To: Anita Gardner <Anita.Gardner@arun.gov.uk>
Subject: FW: Planning Consultation on: A/26/21/RES

Application ref: A/26/21/RES

Description: Approval of reserved matters following outline consent A/44/17/OUT for appearance, landscaping, layout & scale for the demolition of existing buildings on site & erection of a mixed use development comprising of 90 No. residential dwellings & a care home & ancillary facilities including railway crossing together with associated access, car parking & landscaping. This application also lies within the parishes of Rustington & Littlehampton.

Location: Land west of Brook Lane and South of A259 Angmering BN16 3JL

Refer to drawing 176-012 for LEAP General Arrangement Plan.

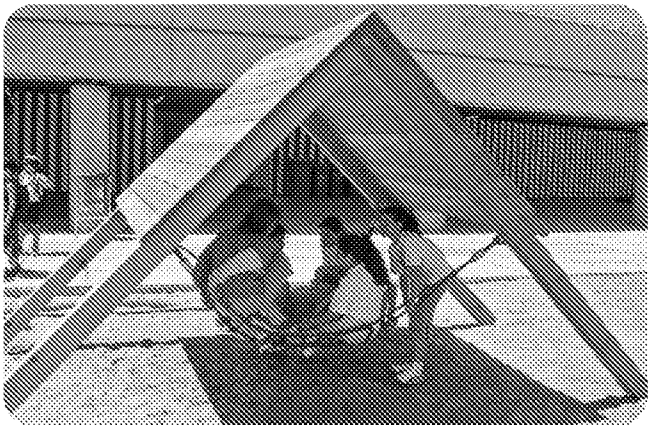
LEAP – provides a good play offer appropriately fenced and gated with a good selection of play experiences and play offer. The play area has proposed an inclusive element of play and is accessible with all-weather pathways. Note the LPA would not be supportive of the Tiger Mulch safety surfacing (assuming this is a loose fill woodchop/bark material) due to maintenance issues should the play areas be maintained by the LPA. A loose fill material would also not be appropriate surrounding/adjacent to the P3B inclusive Orbit roundabout. The LEAP layout plan also incorrectly denotes PB3 as a swing when it is a rotating item.

- 1. LEAP –** (drawing ref: 176-012) – *the tiger mulch safety surfacing is actually a bound surface. However, there are other products available therefore we have put in the key as "Bound rubber mulch surfacing". An example of such product is as follows: <http://www.rtcasafety.co.uk/rubber-mulch/>. The play equipment P3B the Inclusive Orbit is amended as a "Rotating" item in both the GA and in the document 176-G102.*

Refer to drawing 176-013 for LAP 1 General Arrangement Plan.

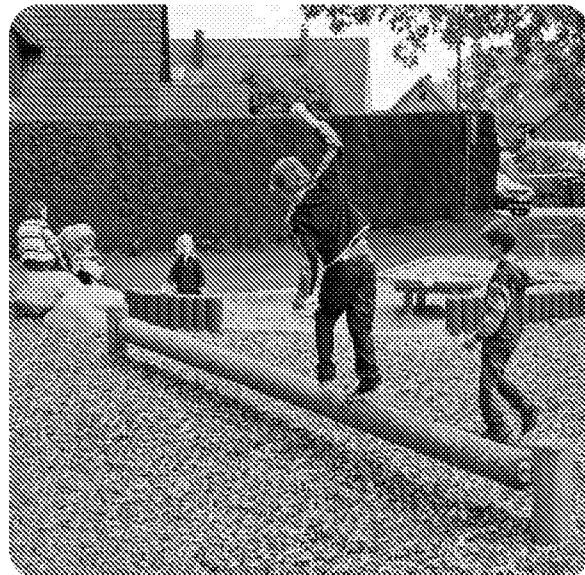
LAP 1 – provides a good informal natural play offer with addition of seating and bin. Safety surfacing shown as crushed gravel, which may not be appropriate for this area. Grass with incorporated grass safety matting (for wear and safety properties) recommended in equipment areas as manufacturers recommendation would be more appropriate for this LAP area.

- 2. LAP 1 –** (drawing ref: 176-013) – *The play area surfacing has been changed to show as amenity grass seed and a note has been made to use the grass safety matting in accordance to the BS for the play equipment.*
